Ref: 6/2021/1527/HOUSE
Date: 21/07/2021

HISTORIC BUILDINGS AND CONSERVATION ADVICE

RE: 22 Rooks Hill, Welwyn Garden City, AL8 6ET

The application is for the erection of part two-storey extension to rear with a garage conversion.

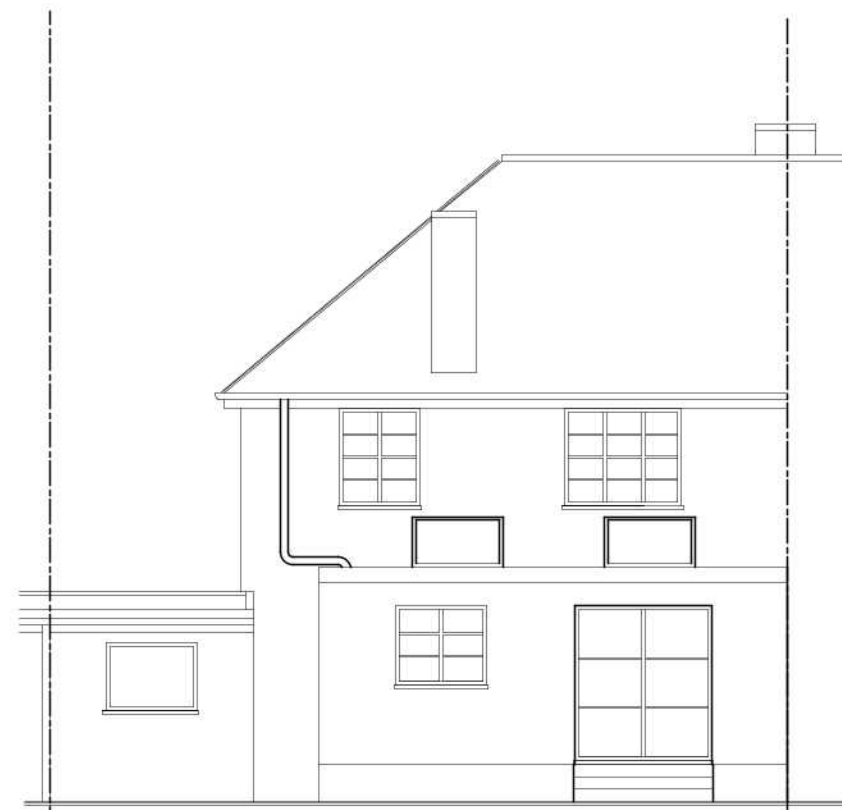
There are no objections to the rear extensions as they are sympathetically designed. In principle, the conversion of the garage and its linking to the main house is acceptable, however, the proposal will see the alteration of the streetscene through the loss of the existing garage and its relocation to create a larger gap.

If the existing garage were retained (and converted) there would be no objection to the proposal as there would be no detrimental impact on the Conservation Area. The original garage doors (seen elsewhere) were side-hung timber doors with glazing to the top third. The use of this style of door could be a potential solution to allowing access to the rear of the property – one door could be fixed shut and one opening with an internal corridor wall between the two allowing access to the rear.

As proposed, the alteration to the garage is considered to have a detrimental impact on the character and appearance of the streetscene resulting in a low level of 'less than substantial' harm to the significance of the Conservation Area. Paragraph 202 of the NPPF (2021) is relevant.
